**RE: Sonata Unit 4 Trails Apartments  
Tracts 1, 2, and 3, The Trails Unit 4  
Third DRB Submittal**

RESPEC, agent for Sonata Trails, LLC, owner of the above referenced property, is requesting approval from the Development Review Board (DRB) on this Site Development Plan submitted for your consideration. This is the second submittal to the DRB for this project. The first hearing was held on June 3, 2020. Below is a response to comments received at the first DRB meeting.

SHEET NUMBER:  
**C-104**

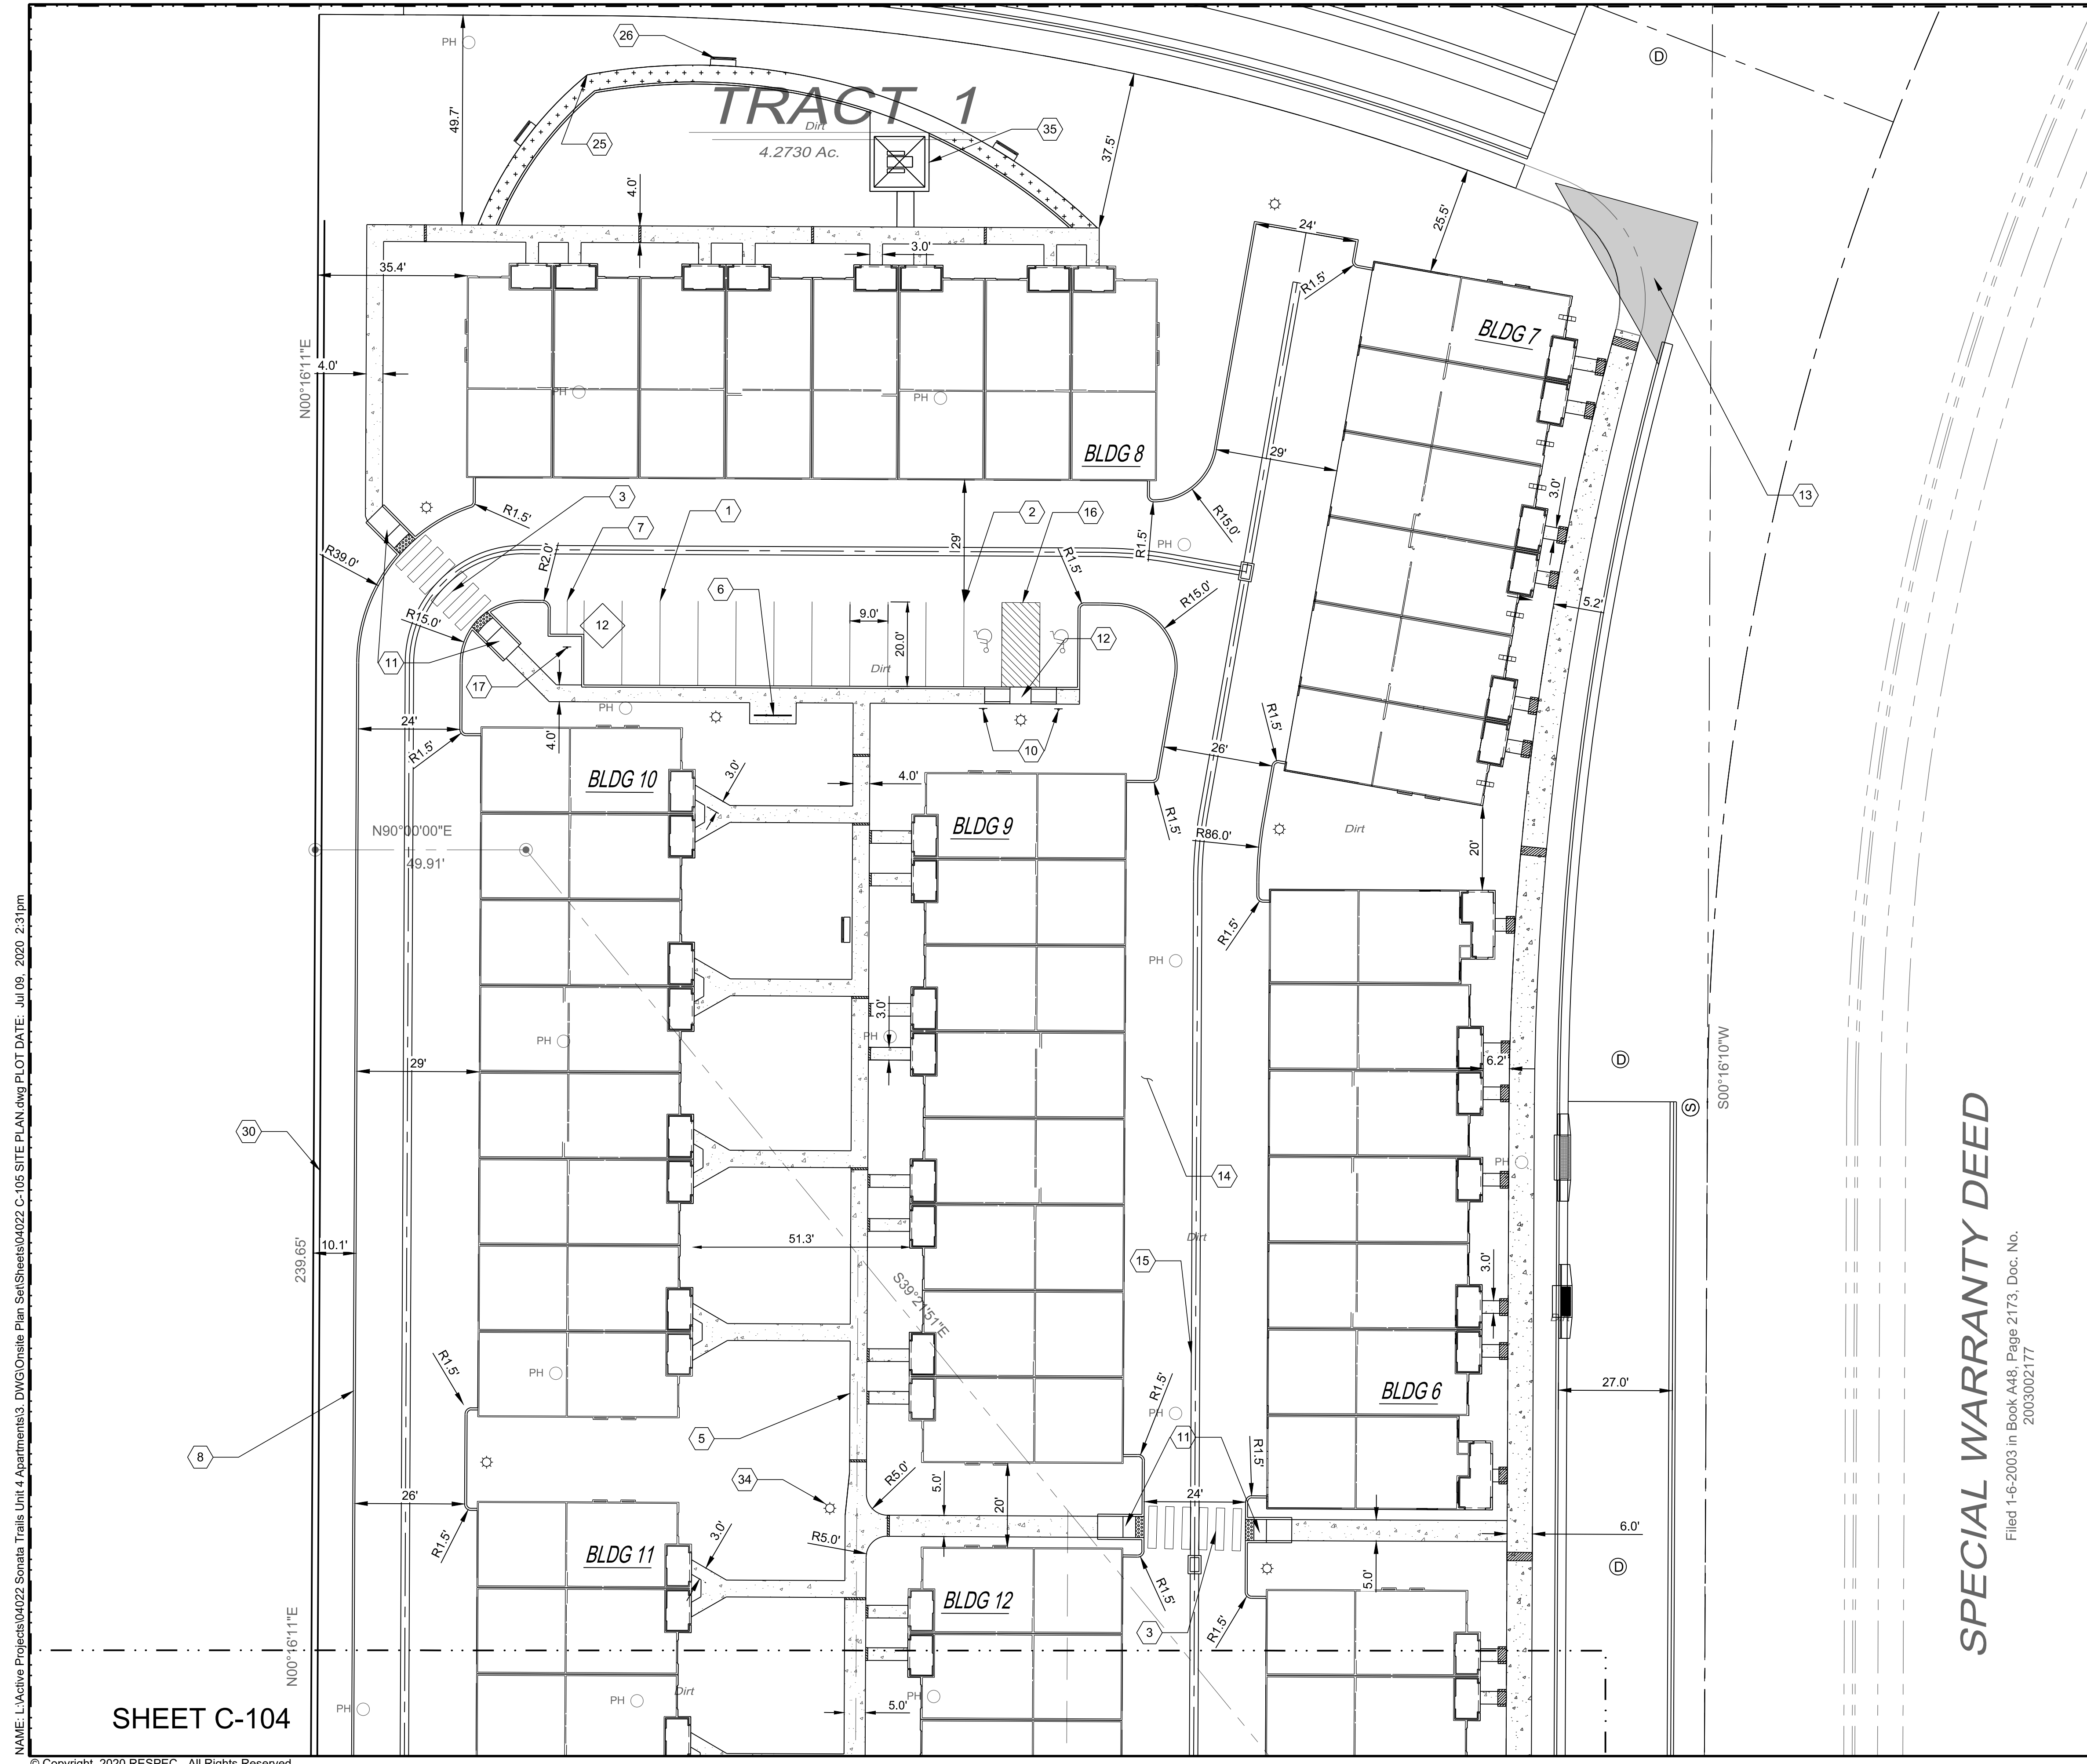
3. Show Oak Ridge limits on infrastructure list. Because roadway improvements are required along the entire length of the site, Chatsworth construction limits should end at Oak Ridge.  
/ Oak Ridge and Chatsworth added to infrastructure list. See revised infrastructure list.

4. Add keyed notes for all ADA ramps on the site plan.  
/ Keyed notes added for all ADA ramps. See revised site plan sheets.
5. Provide motorcycle parking sign detail.  
/ Motorcycle parking sign detail provided. See revised detail sheets.

6. A 6-foot minimum sidewalk width shall be provided from main building to right-of-way and from handicapped spaces at main building to building entrance. (The width shown is 5 feet.)  
/ The 6' ADA path provided is at the western-most sidewalk connection to Tree Line Ave, then heads north across the drive aisle and turns east until reaching the clubhouse building.

7. Add a keyed note for crosswalks on the site plan.  
/ Crosswalk keyed note provided. See revised site plan sheets.

8. Add a keyed note for clear sight triangles on both landscaping and site plan.  
/ Keyed note for clear sight triangles provided. Also added at public intersections. See revised landscape and site plan sheets.
9. Dimension all parking spaces. All curb radii need to be labeled.  
/ All parking spaces and curb radii have been dimensioned and labeled. See revised site plan sheets.
10. Provide roadway cross-section for Woodmont prior to second phase of development.  
/ Acknowledged. A roadway cross-section for Woodmont will be provided when Tracts 3 and 4 to the south develop.

- In addition to seeing the plat and right-of-way dedication, he wants to know what the ultimate design will look like both at the Treeline intersection and at the Oak Ridge intersection even though you are expected to just build your half. He wants a clear picture of right-of-way dedication and making sure that it is workable. He wants to know what you are dedicating and what is proposed for dedication for other future developers.  
/ Future roadway linework added for clarity on right-of-way dedication. See revised site plan sheets.

- I believe on Treeline, he was unclear about the design. It might help to just show that temporary transition length when you go from a full road section to a half road section.  
/ Temporary transition length from full to half section labeled. See revised site plan sheets.
